Application by Tritax Symmetry (Hinckley) Limited for an Order Granting Development Consent for the Hinckley National Rail Freight Interchange

Registration and Relevant Representation Form

Hinckley National Rail Freight Interchange – Tritax Symmetry Application for Development Consent

**M69-A47 LINK ROAD GENERAL ARRANGEMENT**

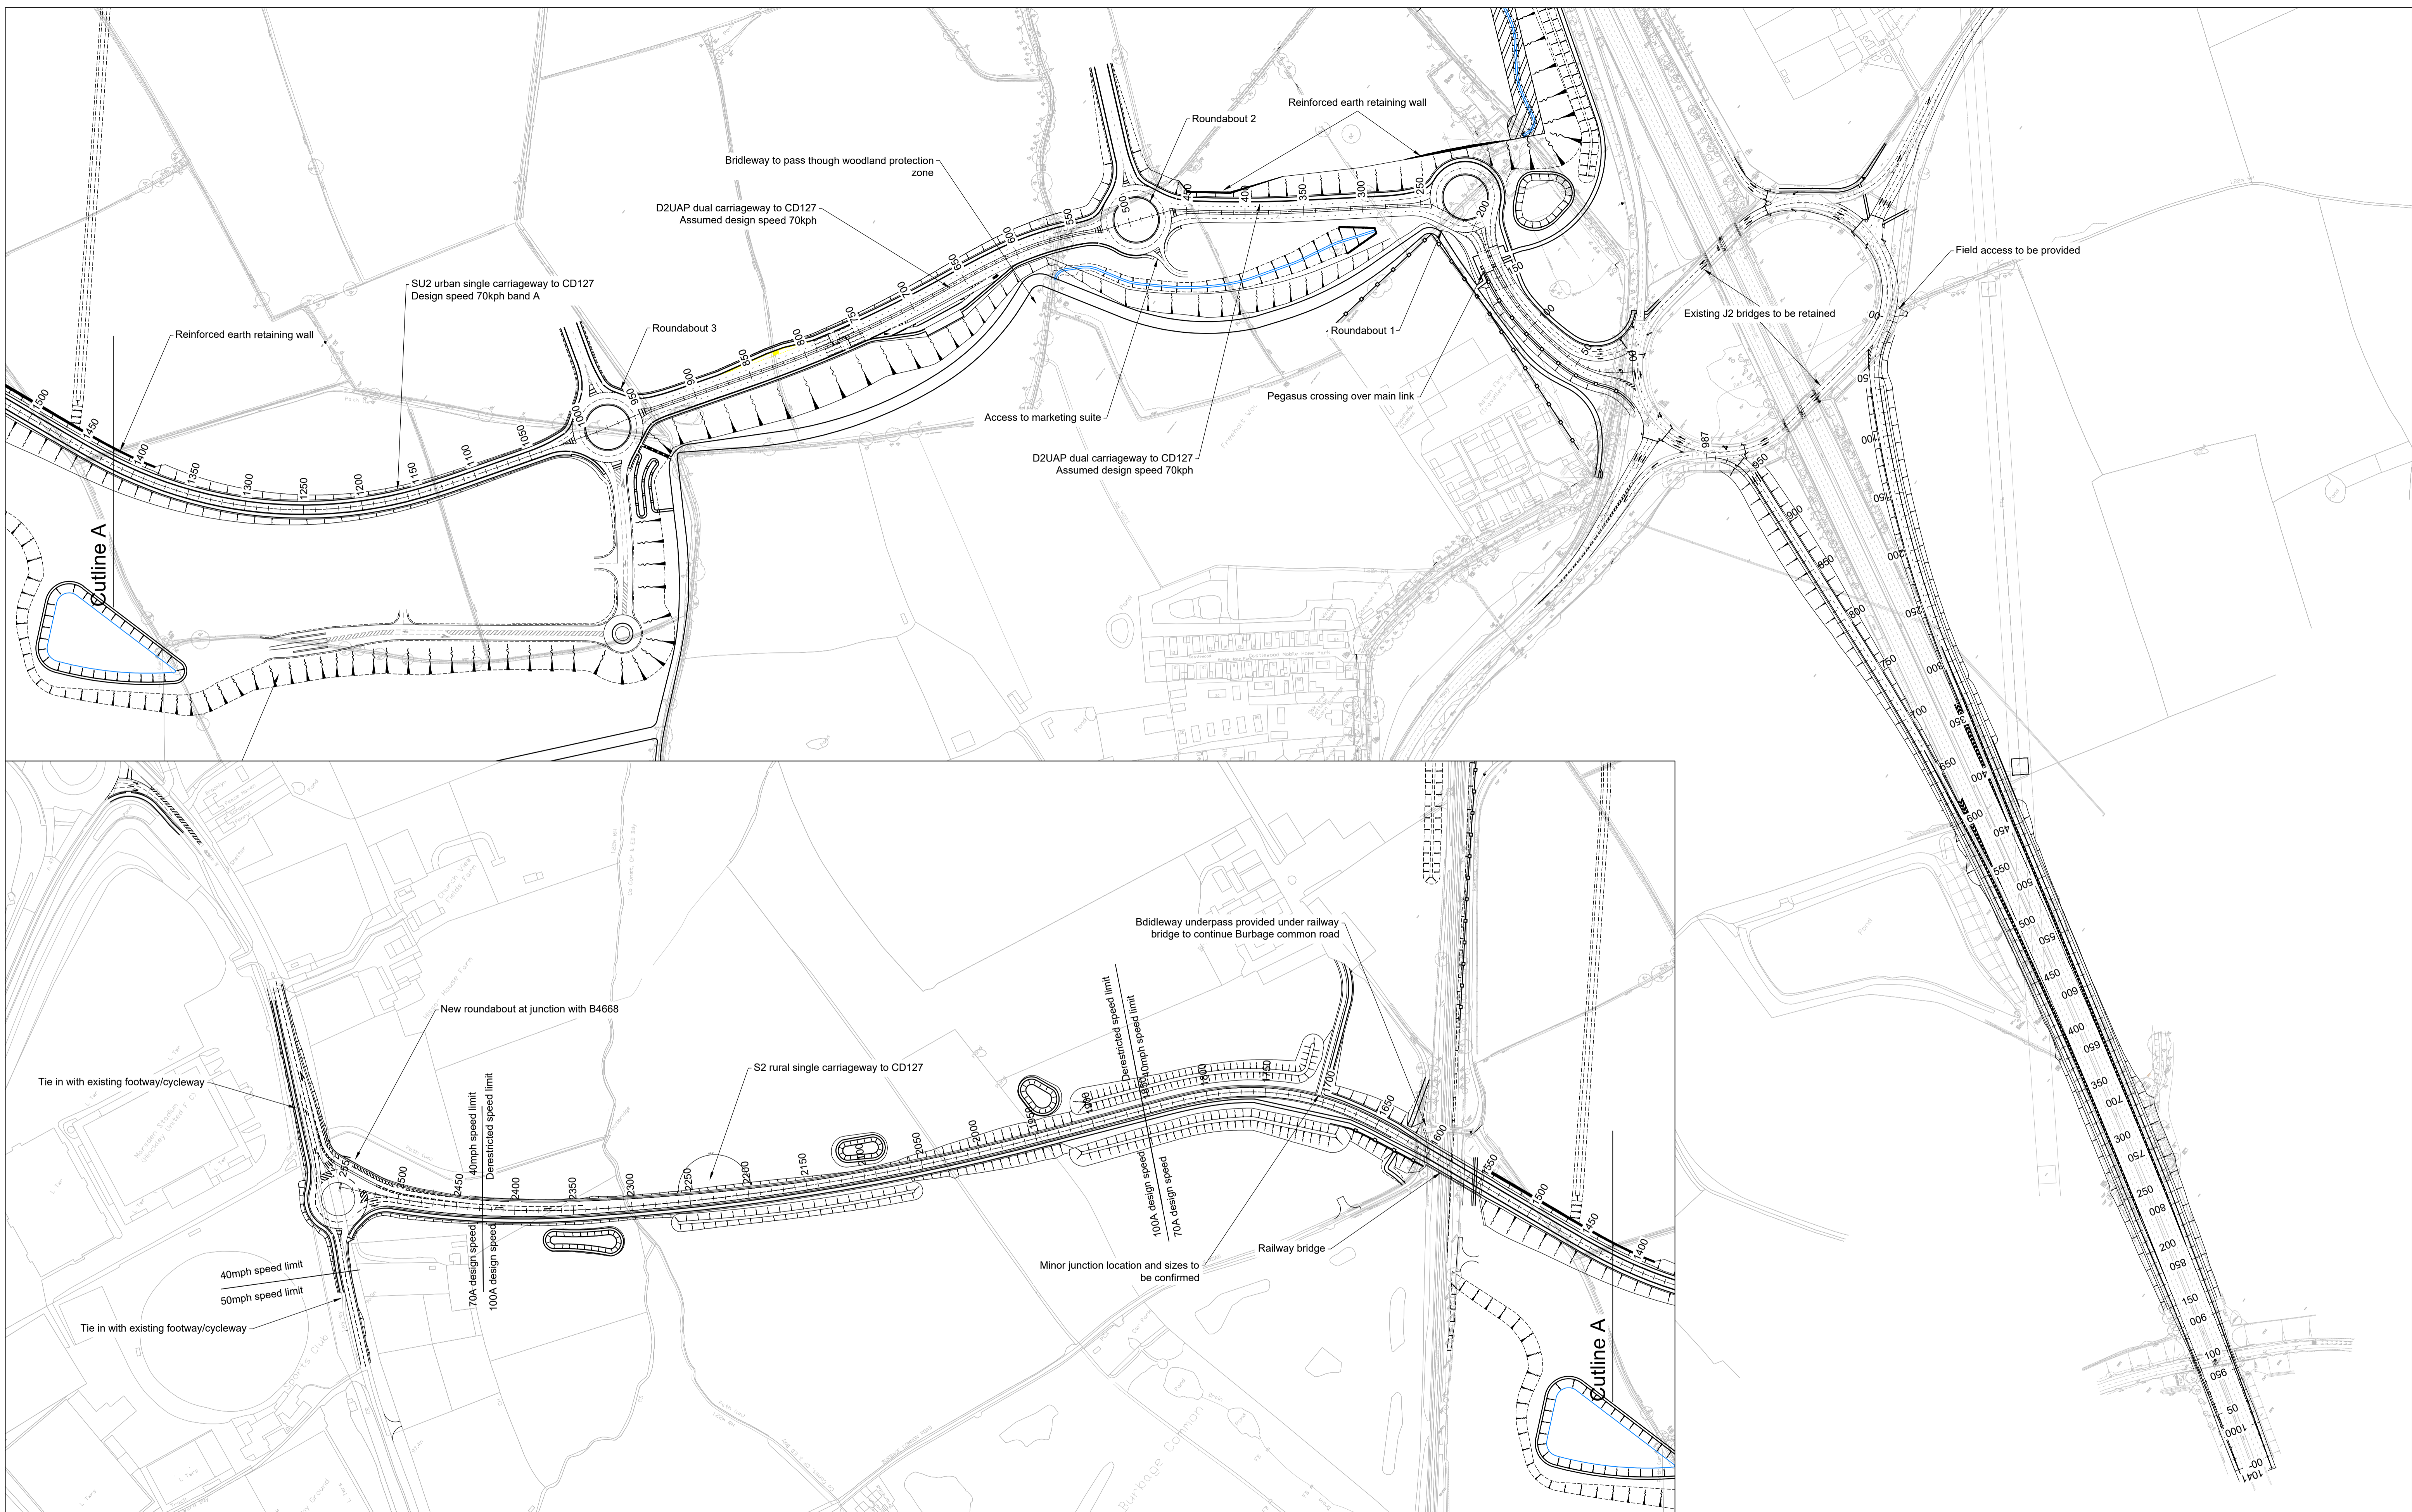
1. Changes to the M69 access road at Burbage to provide a link to the A47 Road will provide access for local and motorway traffic, in addition to the existing feed from Leicester, Earl Shilton, and Barwell which has already brought the traffic flow near to saturation point particularly at the start and end of the working day, where traffic queues up to the Ashby Road traffic lights at the B4667/ A47 intersection extend back at least half a mile. The additional traffic load will result in further bottlenecks at the Ashby Road traffic lights and longer queues past our back garden which is located just 0.1 miles down the A47. I feel that rather than seeking ways to increase an already overloaded road, we should be seeking ways to mitigate the situation by alternative routes. I understand that in addition to the housing project already being built below the Triumph factory, similar housing is planned along the set-aside areas of farmland up to the Ashby Road crossing and thereon to Barwell village. This will result in a significant number of new builds and with each household on average owning 2-3 cars, problems will arise with this additional traffic load being disgorged onto the A47.

3. The proposed road link off the M69 interchange to the A47 is designed accommodate the carriage of heavy-duty construction materials to the project site, and hence in addition to increased traffic flow, brings with it the use of more heavy-duty multi-axle road haulage vehicles, often with double-trailer set-ups (now already a common sight), with deleterious effects on road surfaces, such as potholes and road surface erosion. HGV's waiting at the Ashby Road traffic lights, start from a level position and on changing gear, quickly descend a steep incline resulting in axles losing contact with the road then impacting the road on regaining contact. This results in our house being shaken by the force of the impact, our triple-glazed windows rattle, and cracks have appeared on internal plastered surfaces. We are now fearful of this process resulting in subsidence of the house foundations. The house was purchased new in 1986 from a reputable builder, David Wilson Homes Ltd, and we are

5. The Tritax Symmetry proposal includes outline plans for certain areas of road verges designated for compulsory purchase. Tritax confirmed to me at their local presentation that these represent areas that would be trimmed to give room for road widening. One such area adjoins my back fence. Tritax failed however to elaborate further on the total extent of such excavations, and none of the neighbours living below me have been notified as Interested Parties. I am left not knowing if mine is the only property singled out for such work, or what purpose would be served by carrying this out on a sole property. In any event I would much rather avoid the hazard altogether, as any collisions could result in the demolition of our back fence, with the possibility of injury /fatality to persons present, Removal of sections of the verge at this point would effectively direct the traffic closer to our back fence. This constitutes the deliberate creation of a hazard. If the A47 needs to be widened, then ample space is available, albeit at added cost on the opposite side of the road where the farmland has already been purchased What remains is a choice between cost and safety.

6. Tritax assured me that Incursions into the verge outside my property would not impact the existing footpath nor any of the street lighting, I hope they will be held to this. They were vague however concerning any service conduits that may have been laid underground, which concerns me as the local area is affected by natural springs, one of which existed as a free-flowing stream running down the grass verge outside my back fence when I purchased the property in 1986. Now however there is no sign of it, having been piped into an underground culvert and turfed over Two of my near neighbours have had sinkholes installed in the past due to waterlogging of their gardens. Such springs are a feature of the local area and I have concerns regarding waterlogging if disturbed in any way.
